Planning & Environment

Mandalong Southern Extension Project (SSD 5144 MOD 5) Request for Response to Submissions

Attachment A

Figure 17 Vertical subsidence along the TransGrid power line at the completion of LW24A

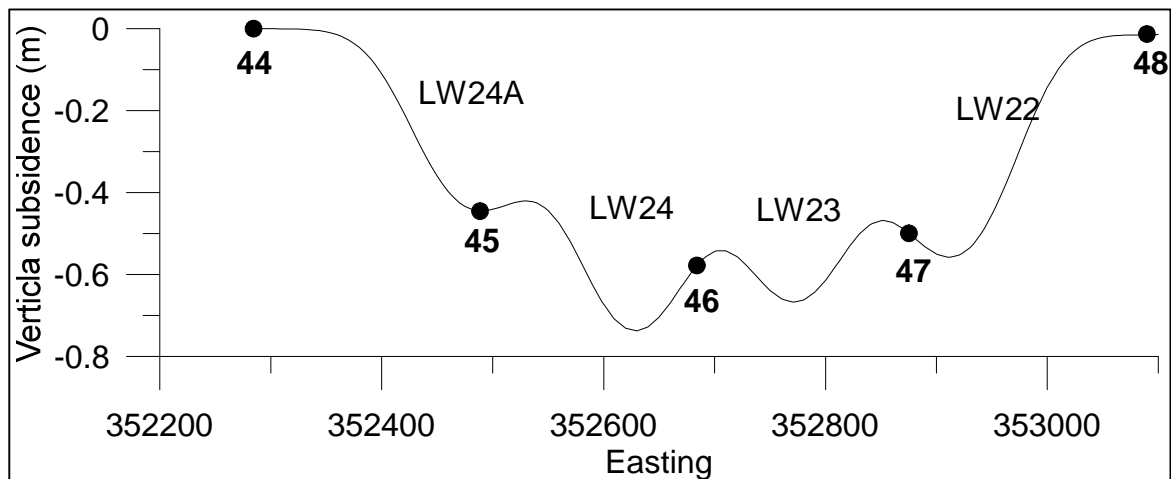
DPE requests additional information / clarification regarding potential subsidence impacts on transmission towers 45 to 47. Section 5 of the Subsidence Predictions Report concludes that predicted strains would have an adverse impact on transmission towers, and that these impacts require "specific attention". However, no further detail is provided and no further mitigation or management measures have been proposed.
